Your Ref: OWPC19106
Our Ref: R/134/18/PL 01-06-2018
Please ask for:
Mrs A Gardner

1 No. end of terrace two storey dwelling
8 Duncton Road Rustington

Thank you for your internet representation made on 6th July 2018 which has been recorded as '**an objection**' with the comments as follows:

Drawing P01      May 2018      Scale 1:100 @ A3  
Planning Drawing - Site Plan & Floor Plans

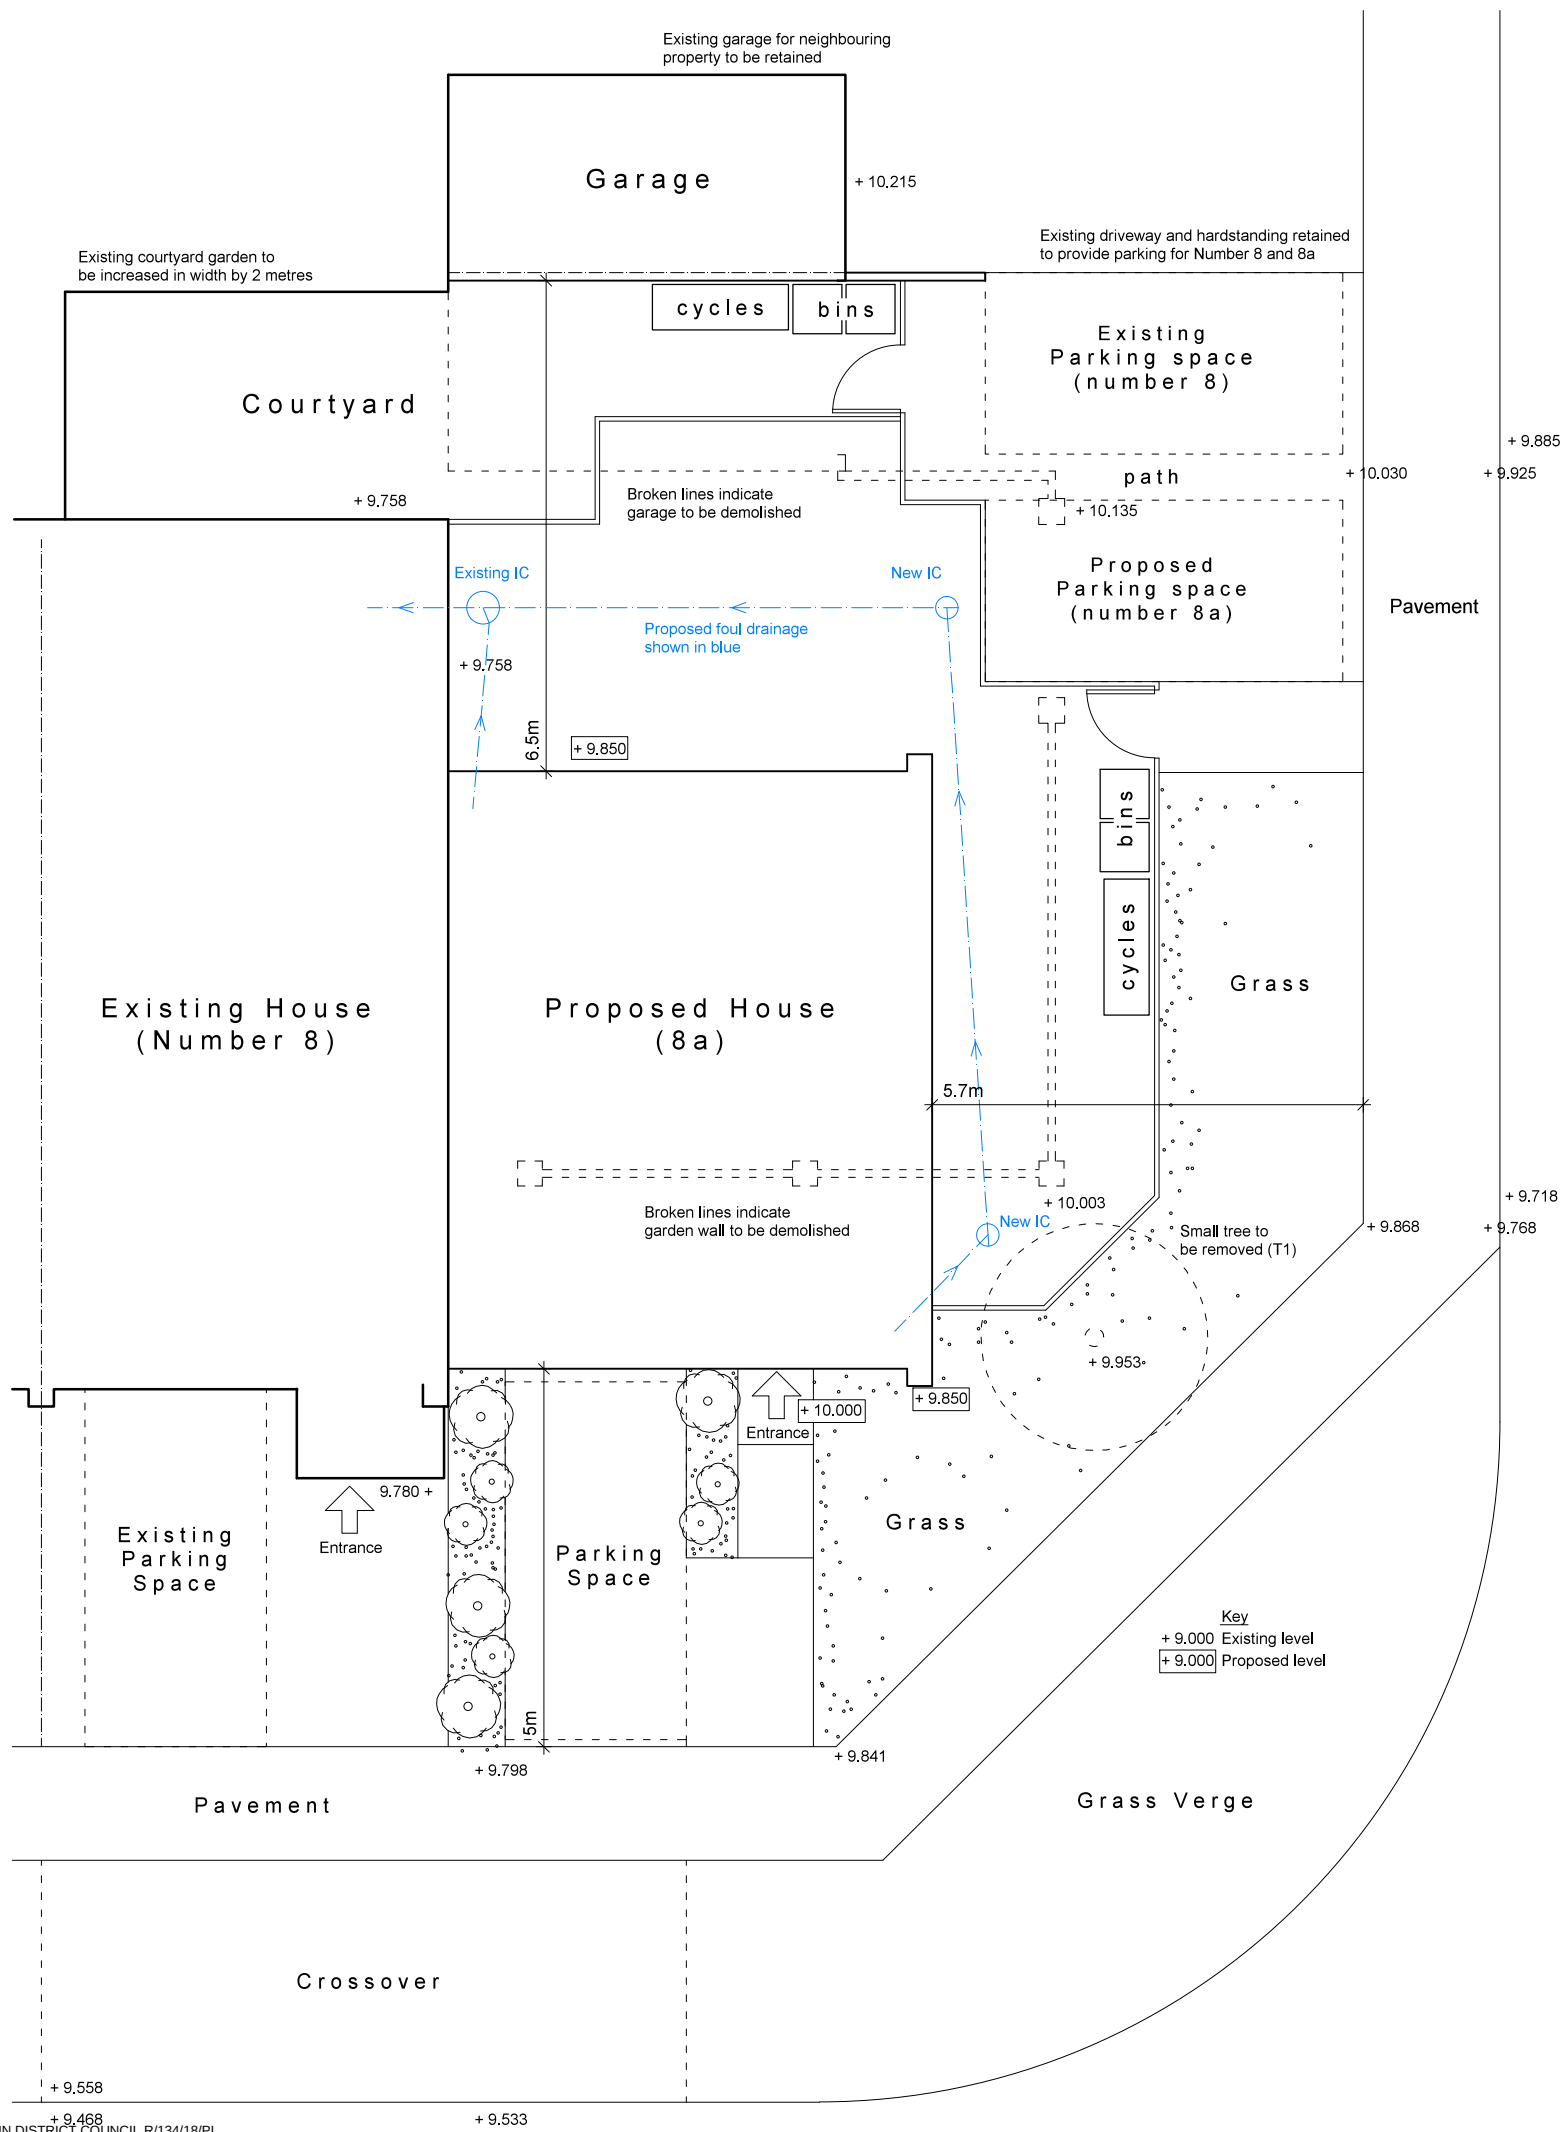
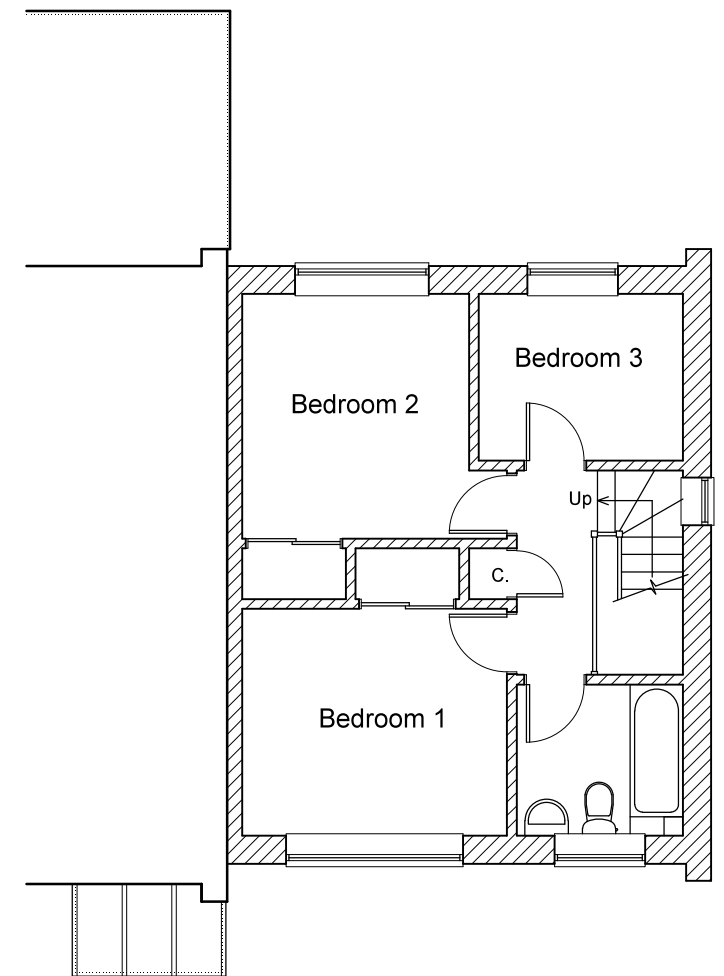
There is a wall planned to extend from the end of the garage what are the dimensions? And which materials and finishings will be used?

Parking spaces do not look big enough for modern cars what are the dimensions? Will larger cars end up parked over the pavements? The current owner has 3 cars onsite currently and only plans for 2 spaces, this will add to the already overcrowded and dangerous parking situation in the surrounding streets.
